**RE: Transmittal of Comments – Amabilis Short Plat (SP-08-00042)**

Thank you for the opportunity to comment on the Amabilis View Estates Short Plat, SP-08-00042. Pursuant to the Memorandum of Agreement between Kittitas County and the Washington State Department of Ecology all residential well connections serving the proposed lots shall be required to have meters installed. Metering results shall be recorded in a manner consistent with Kittitas County and Washington State Department of Ecology requirements. The requirement to meter only applies if you rely upon the RCW 90.44.050 exemption from permitting through ecology.

SUBJECT: Amabilis View Estates Short Plat SP-08-42

**K.C.S.P. NO. 08-00042**

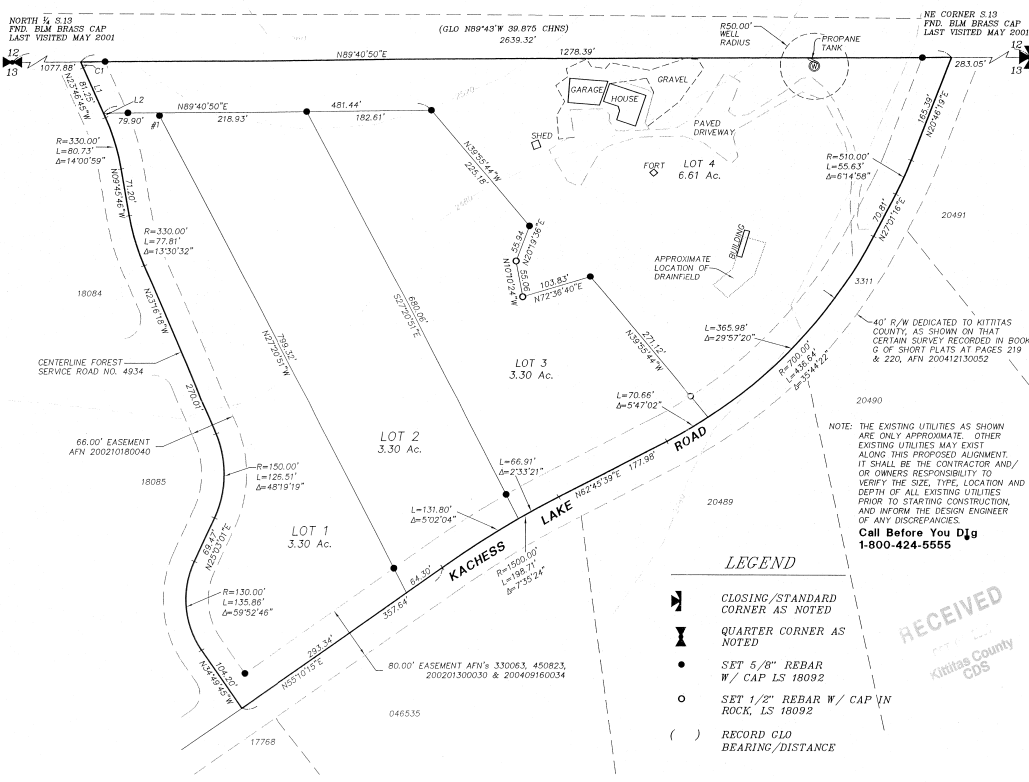
1. County Road Right-of-Way: 40' shall be dedicated to Kittitas County for the Kachess Lake Road right-of-way.

3. Access: Kachess Lake Road is classified as a Rural Minor Collector with a speed limit of 35mph. Accesses must meet the 150' spacing requirement. Joint-use accesses may be required.

4. FS Road 4934: No access from FS Road 4934 will be allowed without approval from the US Forest Service.

- c. Any further subdivision or lots to be served by proposed access may result in further access requirements.
6. Plat Notes: The second sentence of plat note number 6 shall read "See Kittitas County Road Standards."
